Re: Tasty Taco MFU #EHFL2303-001

The application and site plan for the above referenced mobile food unit has been reviewed and is disapproved at this time. Please provide the following:

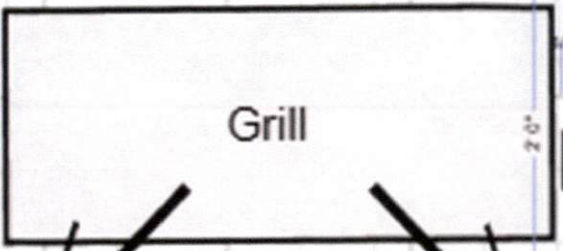
3. You indicated on the application rice will be hot held prior to serving. Indicate where rice is stored hot prior to serving.
4. Indicate where potable water source is located at commissary. Exterior source of potable water requires a covered, protected faucet. The location of wastewater disposal cannot be used for getting the potable water.

5. Do you intend to offer drinks? If so, provide a list of drinks on the menu and describe, canned, bottled, etc.? Provide specifics on location and equipment for drink storage.
